CITY OF ALBUQUERQUE

July 31, 2024

**RE: Cibola Loop Multifamily
Conceptual Grading Plan
Engineer's Stamp Date: No Stamp Date
Hydrology File: A13D011B**

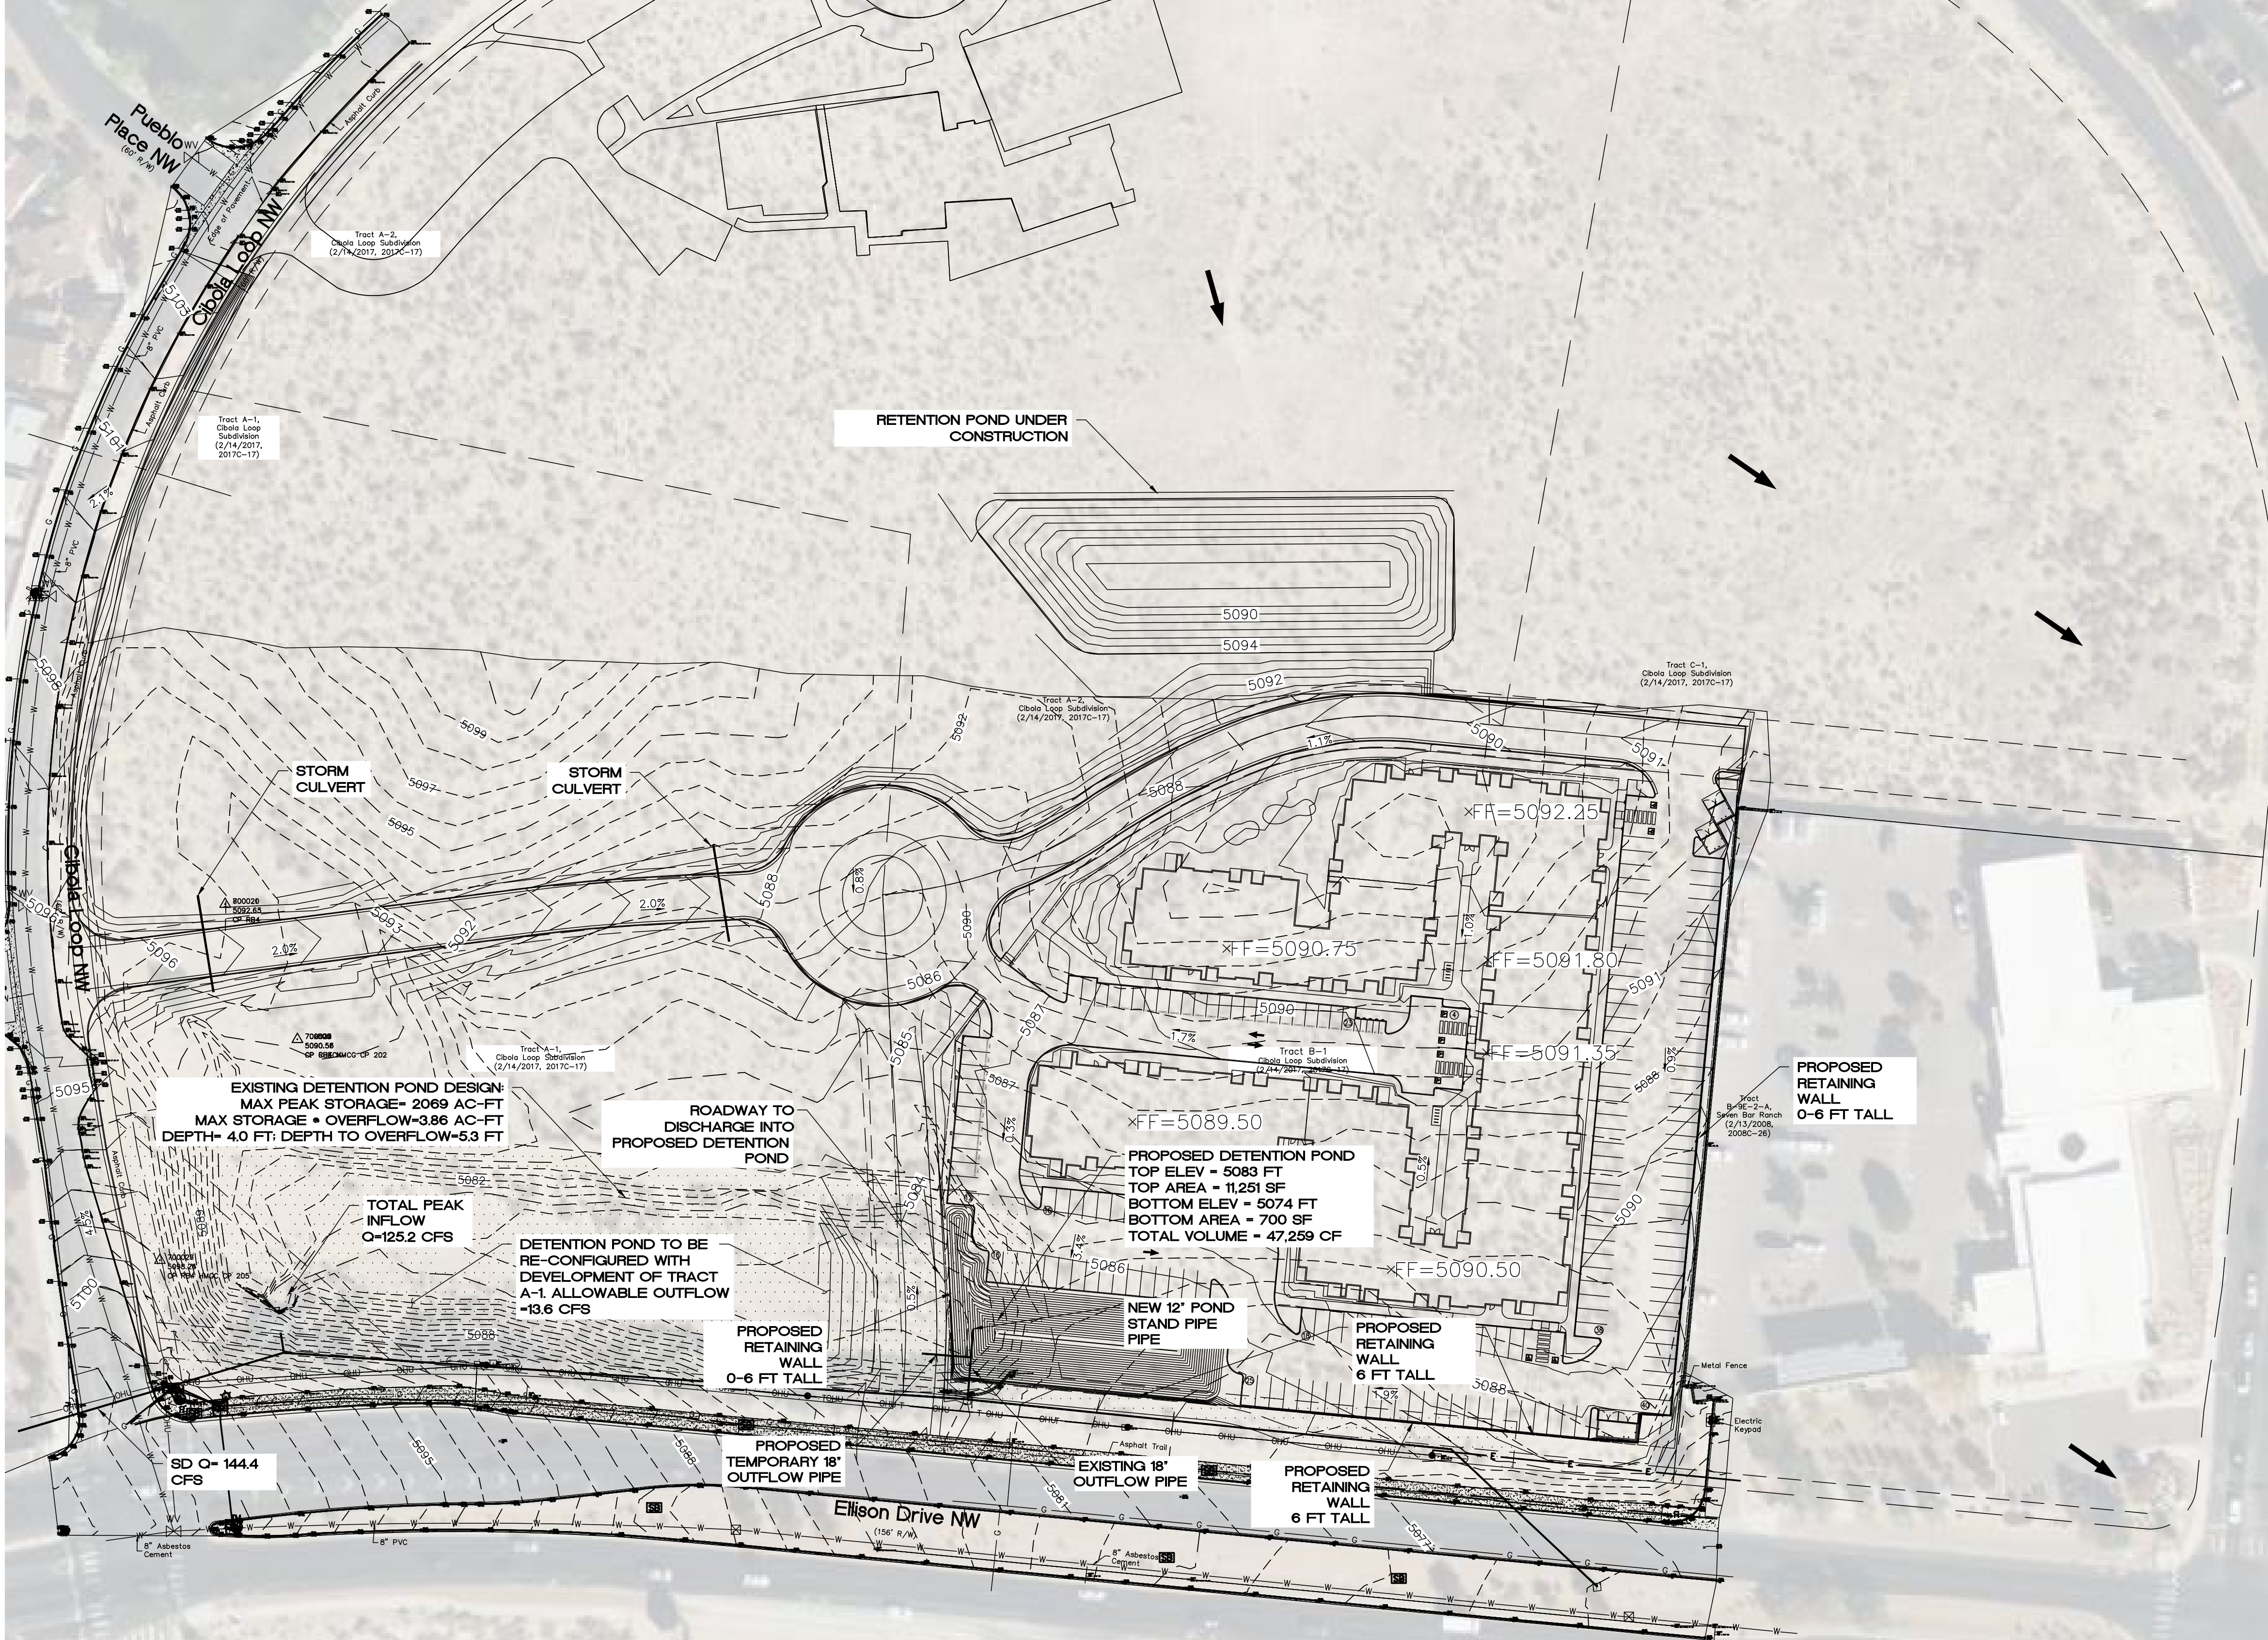
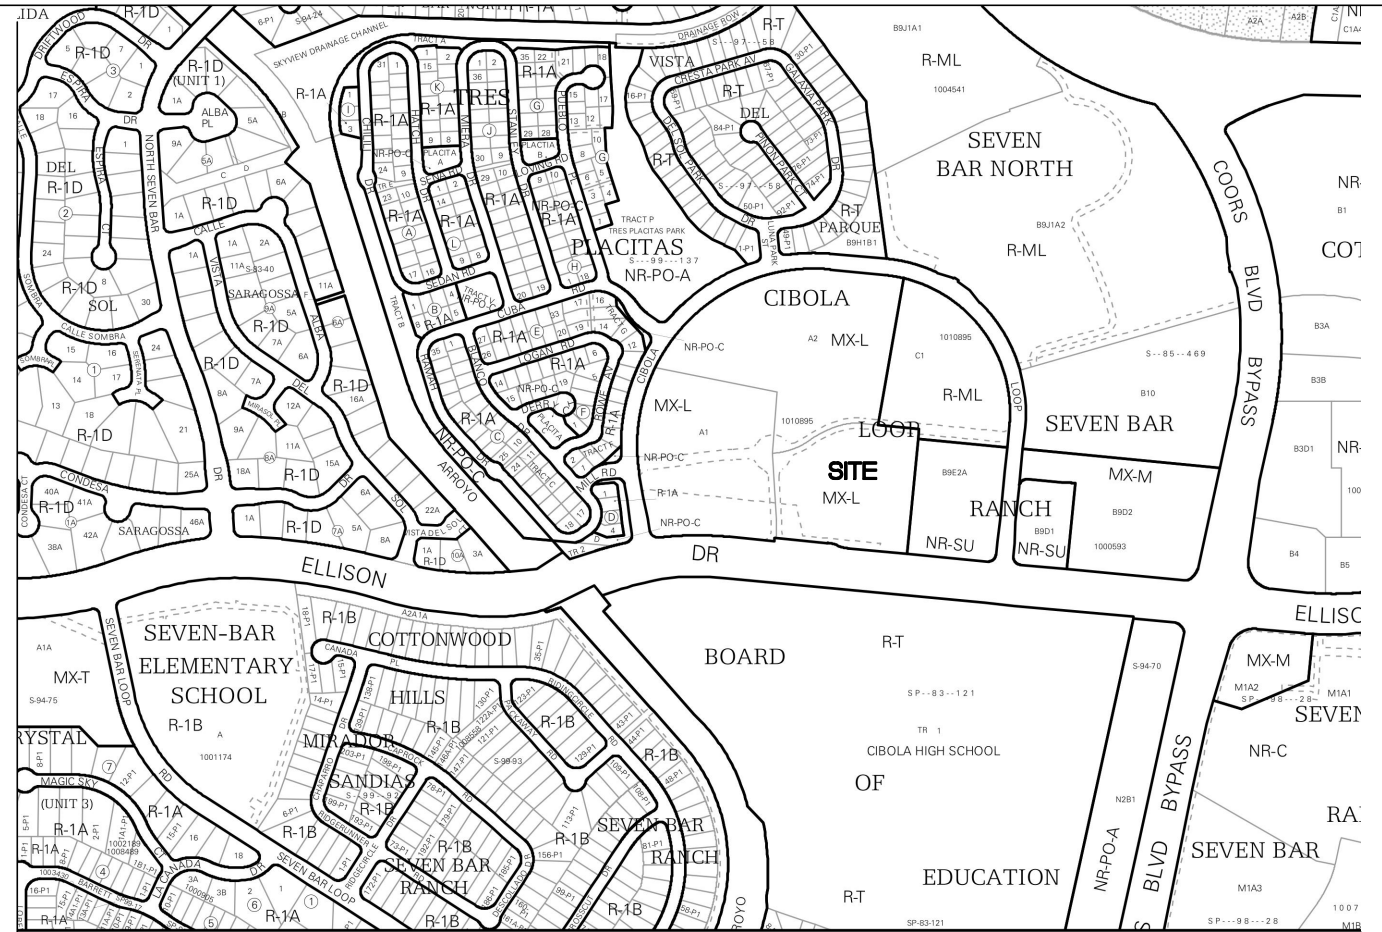
1. Please show the existing CoA Police Station that is on Tract B-9E-2-A which has been there since 2011. I do not think that the shown contours are current and reflect the benchmark change. This should be updated.

- Please show the future development of the CoA Cibola Loop Multigenerational Center on Tract A-2 (A13D025). Please note that there is a proposed retention pond near the proposed access road. This is currently under construction.

- Please provide the Benchmark information (location, description and elevation) for the survey contour information provided.
- Please provide the legal description of the property.

- This site will need a Sensitive Lands Analysis per the IDO (5-2(C)).
- Please use the procedure for 40 acre and smaller basins as outlined in Development Process Manual (DPM) Article 6-2(a). Please provide both the existing conditions and proposed conditions for the 100 year-6 hour storm event. A statement "Refer to pervious Grading & Drainage Report HydroTrans A13D011B." is not acceptable.

- Please provide calculations for the proposed detention pond.
- Please provide a section of the proposed detention pond showing the top of bank and the bottom of bank. Also, please show the location of the maintenance ramp.

- The proposed pond itself looks funny and appears to be just a vee shaped. There will not be much volume in this design. Please correct with the calculation that were requested in Comment #5.

10. Please provide the calculation for the required Stormwater Quality Pond per the DPM Article 6-12. To calculate the required SWQV, multiply the impervious area draining to the BMP by 0.42 inches for new development sites.
